**DELEGATED DECISION FOR APPLICATION FOR CERTIFICATE OF
LAWFUL DEVELOPMENT**

Reference no.: 2025/CL/91428/W

Site: 46, Bank End Lane, Almondbury, Huddersfield,
HD5 8ES

Description: Certificate of lawfulness for proposed erection of
single storey side extension

DWG NO. 2508 - 01

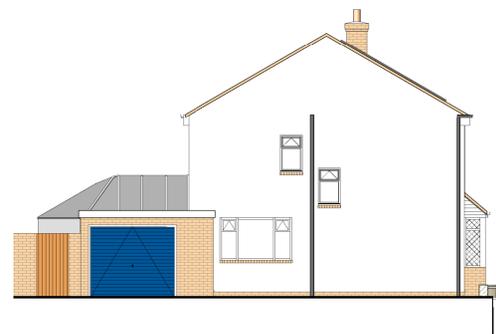
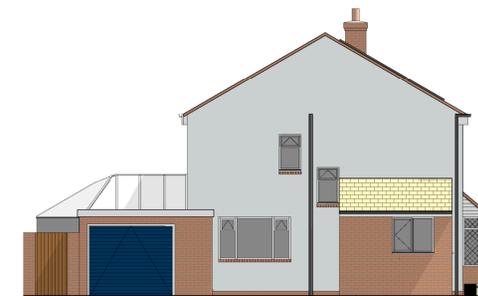
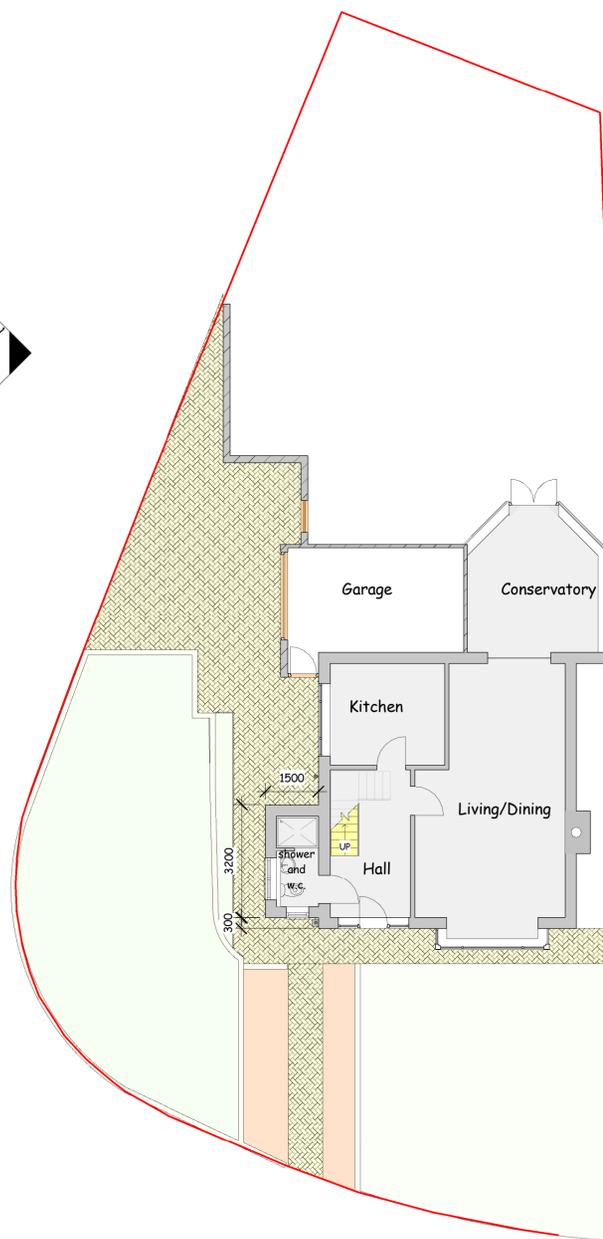
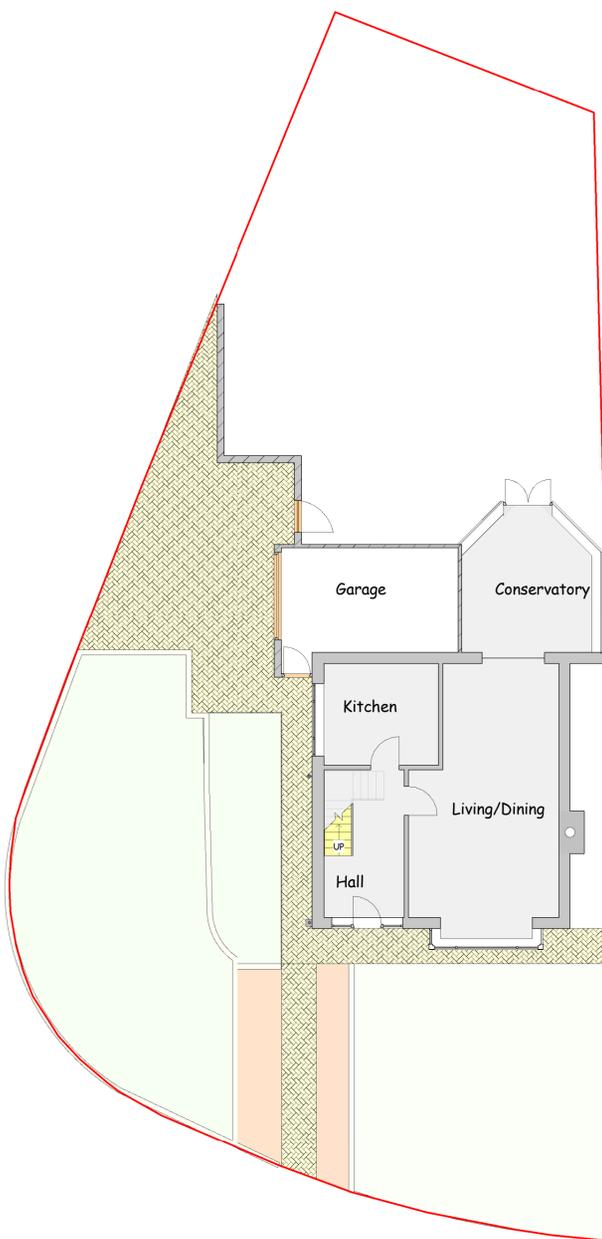
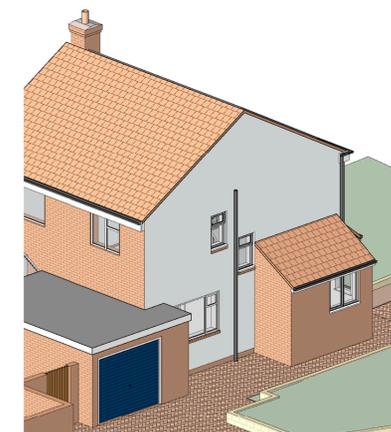
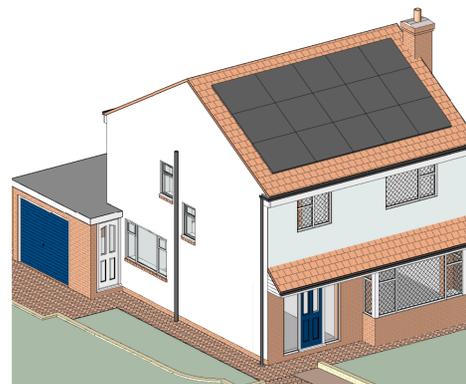
The extension would be set back from the front elevation of the property by 0.3 metres, projecting to the side by 1.5 metres and would be a total depth of 3.2 metres. The eaves height would be 2.3 metres with the overall height being 3.2 metres.

Comment: *The enlarged part of the dwelling would not extend beyond a wall which forms the principal elevation of the original dwellinghouse. However, it*

would extend beyond a wall which fronts a highway and forms a side elevation of the original dwellinghouse.

Comment: *The enlarged part of the dwellinghouse would extend beyond a wall forming a side elevation of the original dwellinghouse however it would not exceed 4 metres in height, would not have more than a single storey and would not have a width greater than half the width of the original dwellinghouse.*

The single storey side extension does not benefit from a general planning permission granted under Article 3(1) and Schedule 2, Part 1, Class A of the Town and Country Planning (General Permitted Development) (England) Order 2015 (as amended) as the proposed development would extend beyond a wall which fronts a highway and forms a side elevation of the original dwellinghouse contrary to sub-paragraph A.1 (e) of Class A.
